DEVELOPMENT REVIEW BOARD
SUPPLEMENTAL SUBMITTAL

PROJECT NO. PR-2021-005716
Application No. SD-2022-00077

SUBMITTAL DESCRIPTION: Suppliment adds application number to the plat, clarifying notes for the private alleyway

Re: Final Plat Review for Proposed Tracts 93A3-A, 93A3-B, and 93A3-C of MRGCD Map 40

**Site Sketch for
Tracts 93A3-A, 93A3-B,
and 93A3-C
MRGCD Map 40
Being Comprised of
Tract 93A3 MRGCD Map 40 and
an Unplatted Parcel
City of Albuquerque, Bernalillo County, New Mexico
June 2022**

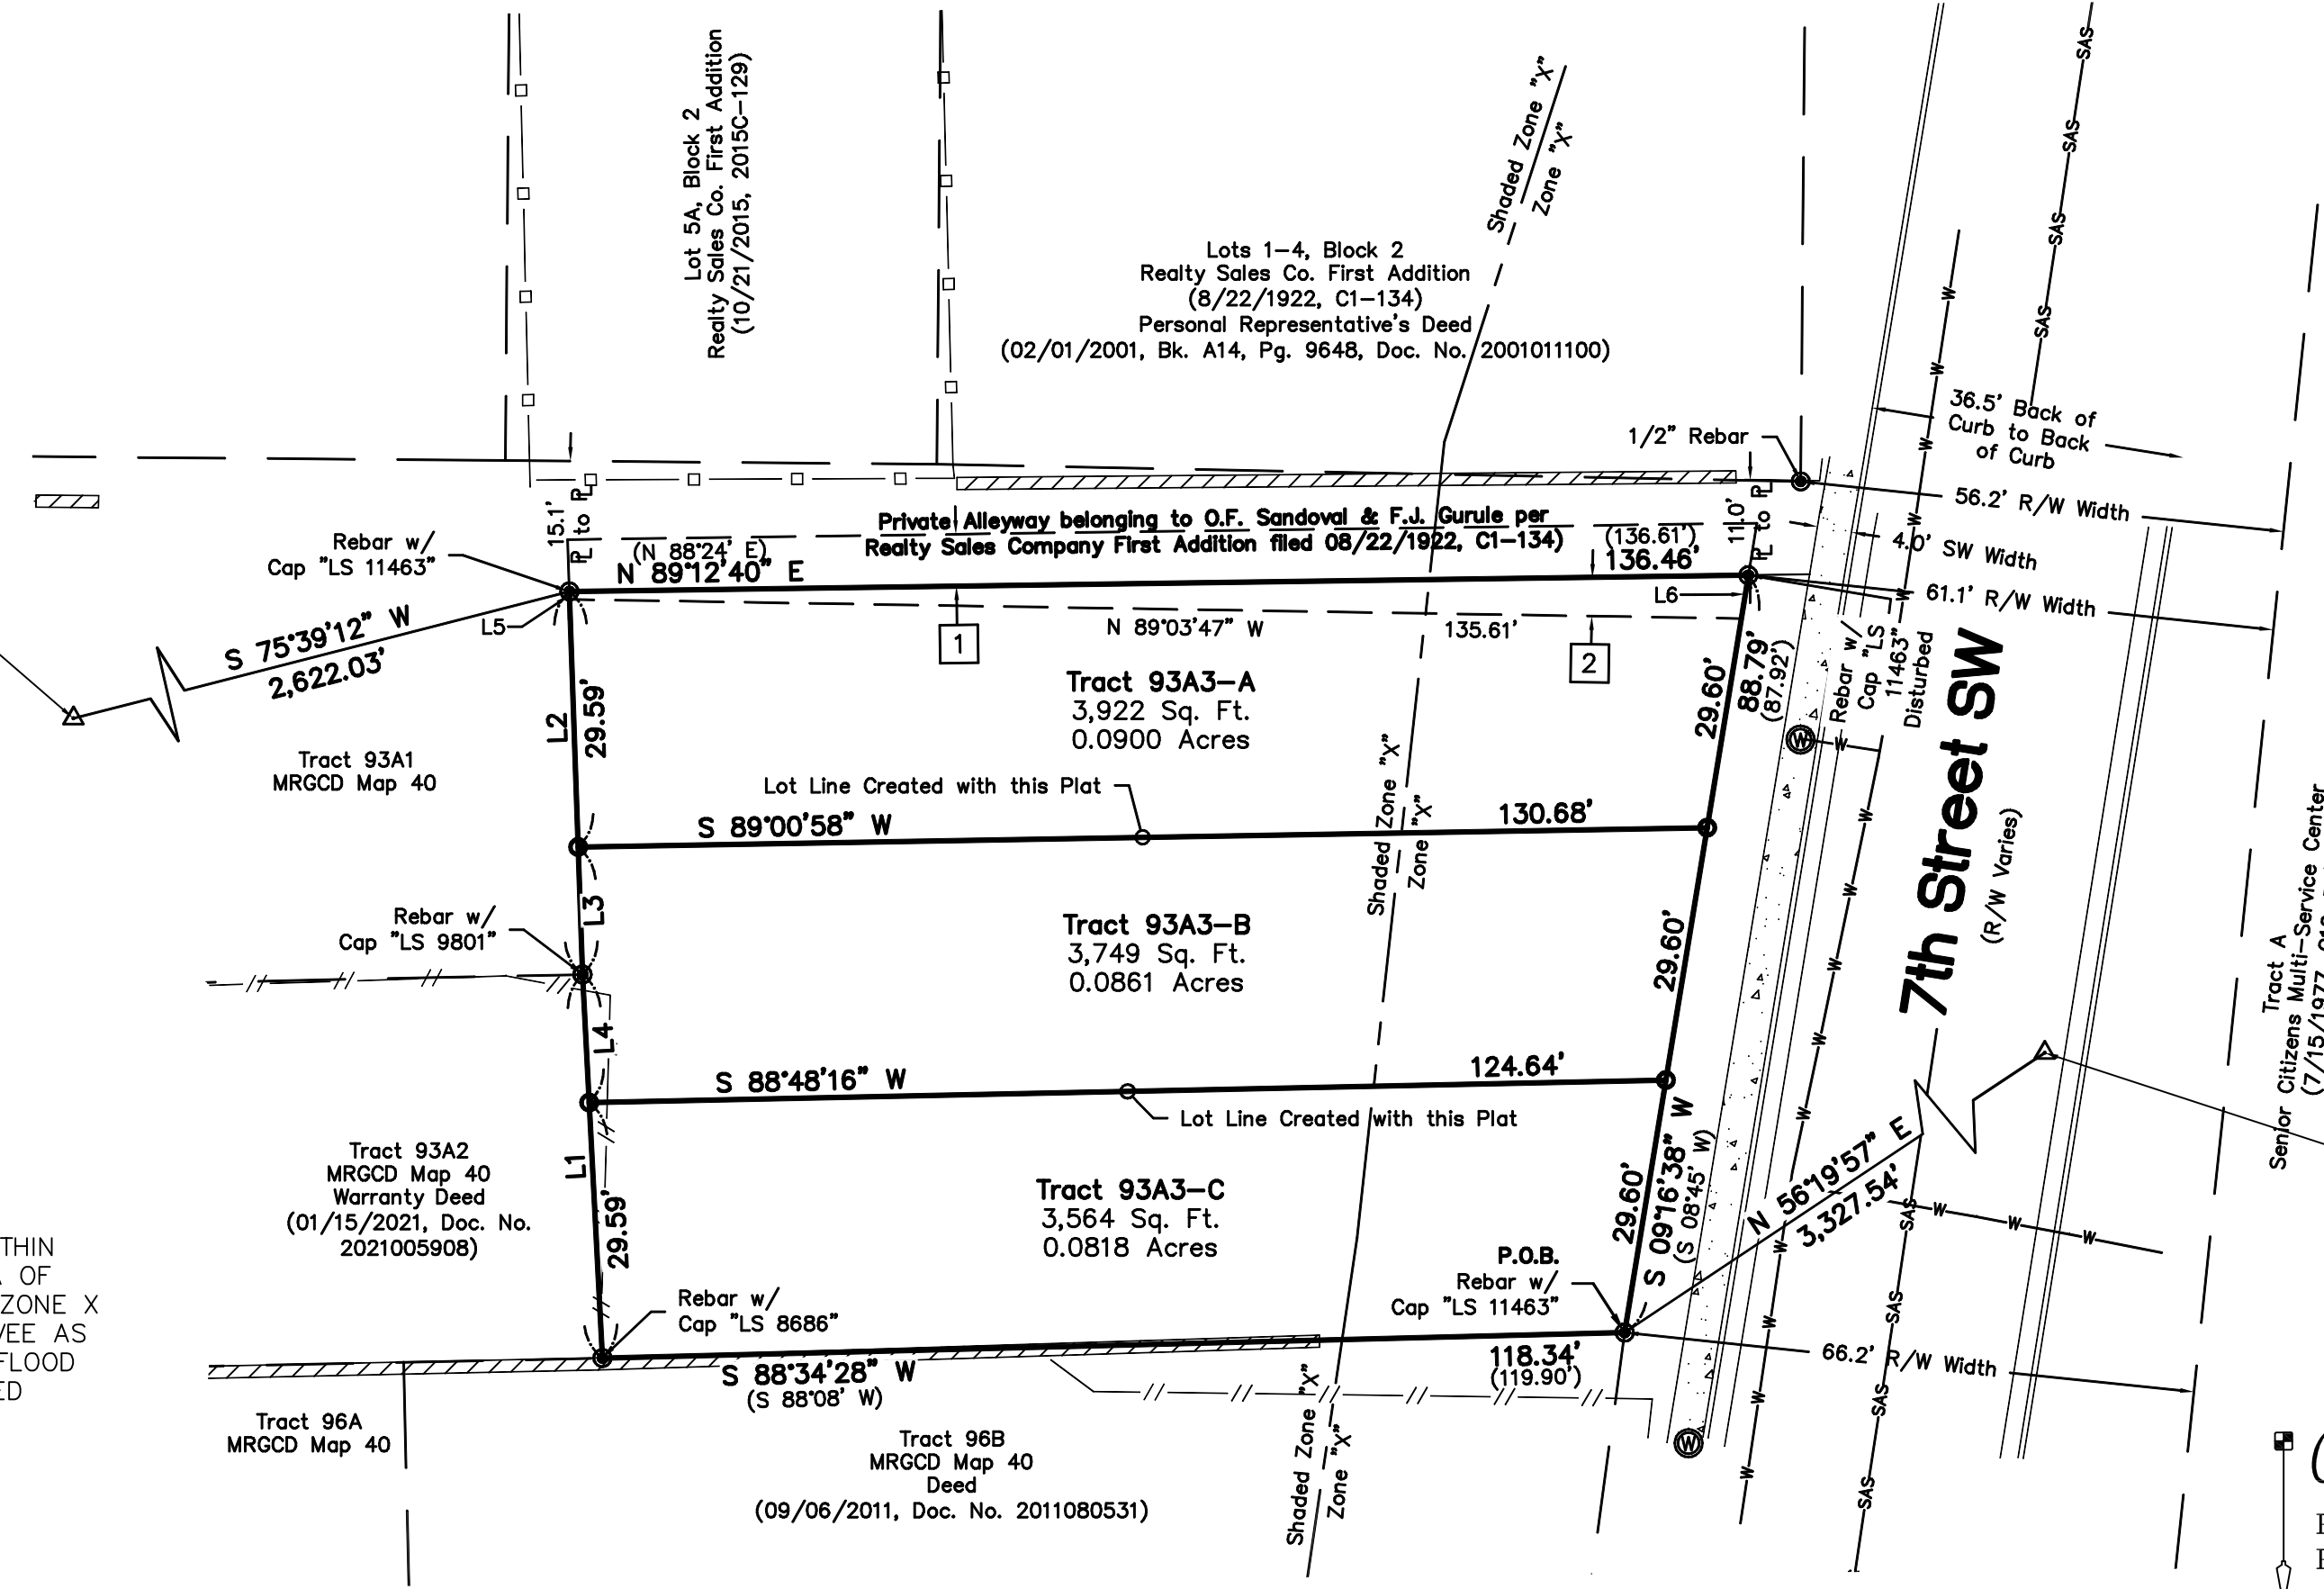
3. Provide curve at the northeast corner of the property to account for sight distance and two-way traffic at 7th Street for the private easement.

Noted, curve is unnecessary due to unused alleyway having no curb cut or indicated use of access.

**Plat for  
Tracts 93A3-A, 93A3-B,  
and 93A3-C  
MRGCD Map 40  
Being Comprised of  
Tract 93A3 MRGCD Map 40 and  
an Unplatted Parcel  
City of Albuquerque, Bernalillo County, New Mexico  
March 2022**

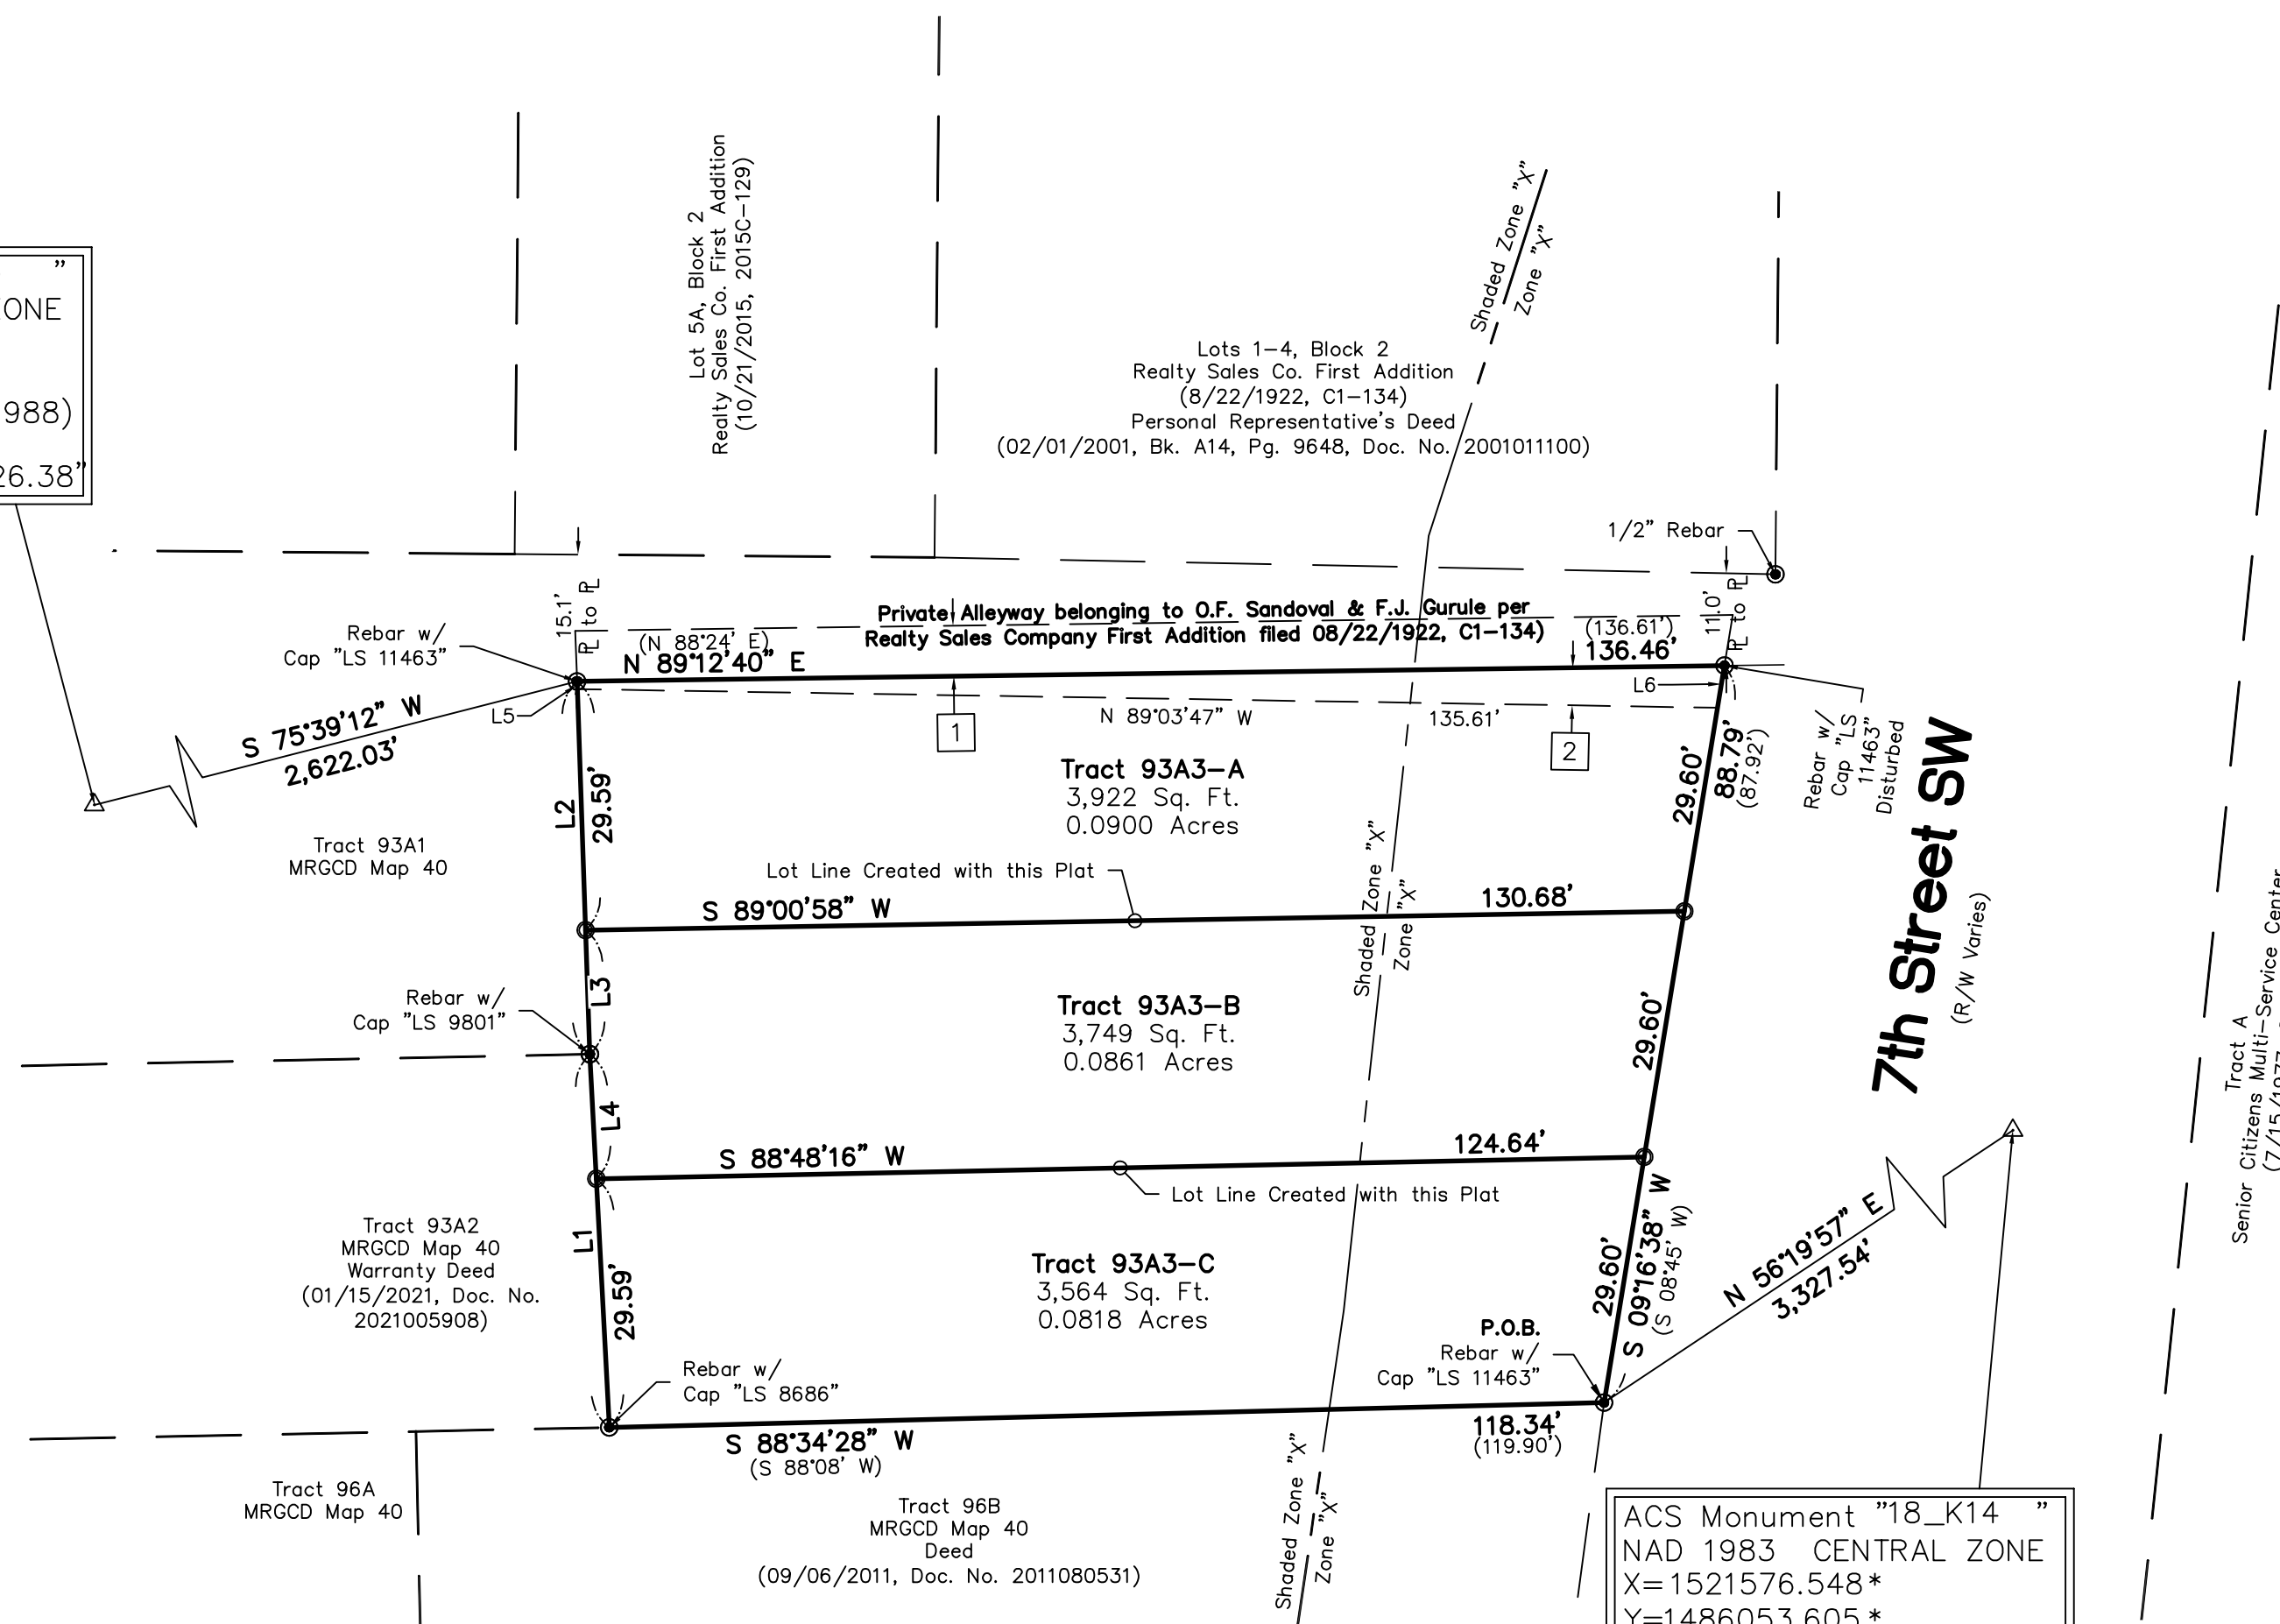
• Plat correction – The land just to the north of Tract 93A3-A is listed as Private Access (shown below) However, this is actually public and not private according to the Bernalillo County Parcels. This was probably an old alley.

1. The GIS indicates that there is public right-of-way where the private access easement is shown. If this is a private access easement, provide the document referenced.

2. The "Private Easement" is not sufficient to handle two-way traffic. If this serves as a secondary access to the businesses, the minimum width should be 20 feet.

- The application number must be added to the Plat.
- The approved ZHE Variances must be submitted.
- The DXF file approval email from AGIS must be submitted.

Noted, a gap in GIS parcel linework is not automatically publicly owned but is a gap in coverage of the GIS linework, as a result of the ambiguous gap where the formally subdivided land of Realty Sales Co. 1st Addition meets MRGCD mapped parcels. The old alley is privately owned by the best evidence Cartesian has been able to find.

The GIS shows a gap in coverage of property ownership due to the ambiguous nature of the property in that area. The best record we have for property is as a private alleyway, per the plat C1-134 which identifies the 7.09 to 14.19 feet south of the Realty Sales Company's First Addition as a "Private Alley belonging to O.F. Sandoval and F.J. Gurule". Subsequent subdivision and replats for Realty Sales Co. 1st Addition describe the land south of those as an alleyway but there is no record of a dedication of the alleyway to the public. South of this alleyway is where MRGCD mapped parcels begin and our subject property is one of these, so between the Realty Sales Co. 1st Addition and our subject lot is a private alleyway and a gap.

Functionally, the lot has no evidence of being used as an alleyway, with no curb cuts or wear in the surface from the passage of vehicles or pedestrians.

Noted, application number has been added to the supplemented version of the final plat. The ZHE variance notice of decision is attached with this application. The DXF approval email is also attached with this supplement.
